Application for a non-material amendment following a grant of planning permission.

Erection of front porch extension	
Reference number:	FP/220/21/HH
Date of decision	19/11/2021

Change of size of front elevation window

Title
Plans as Proposed

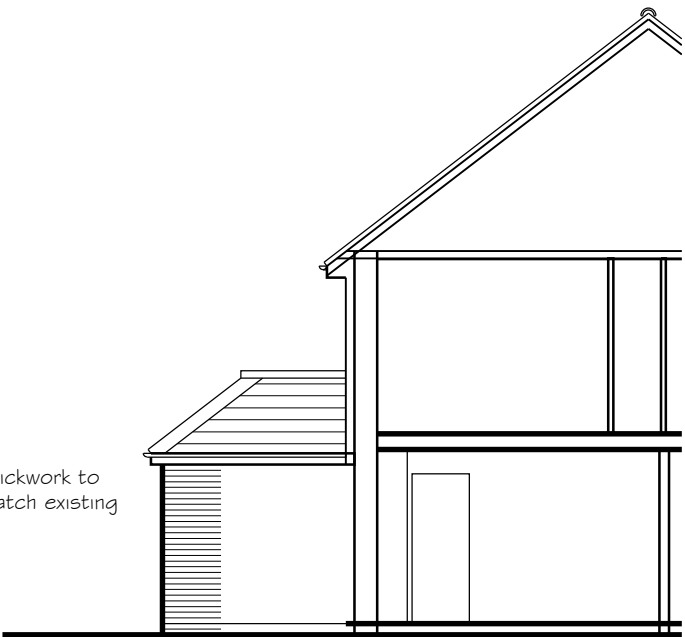
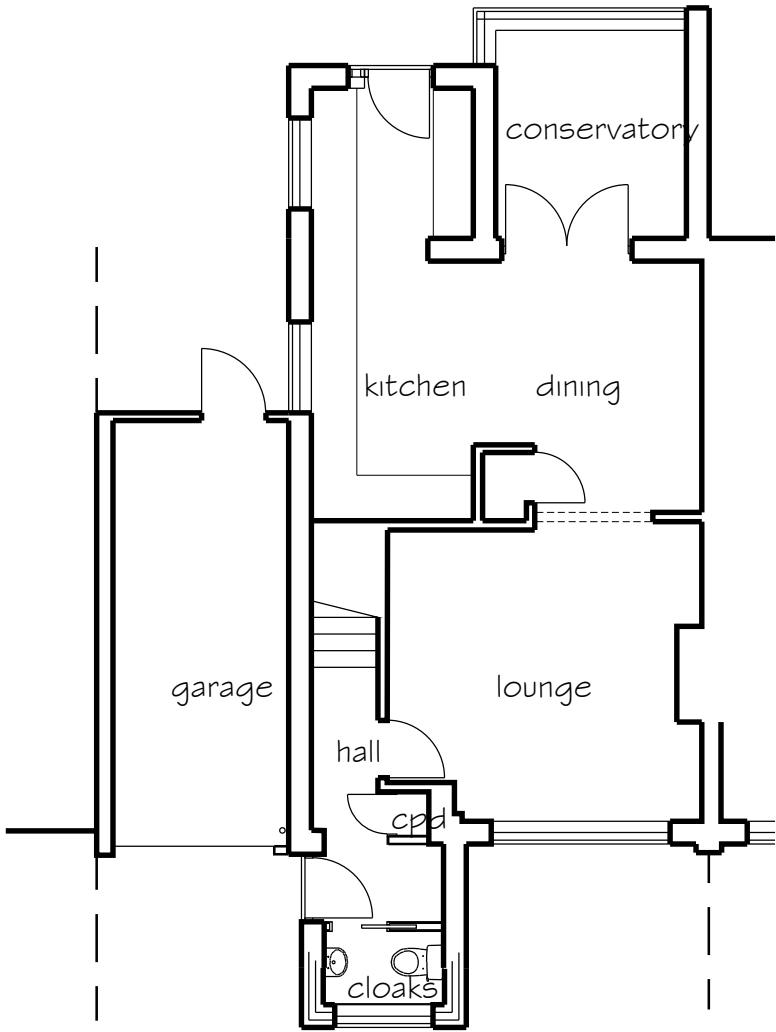
Client request to change of size of window
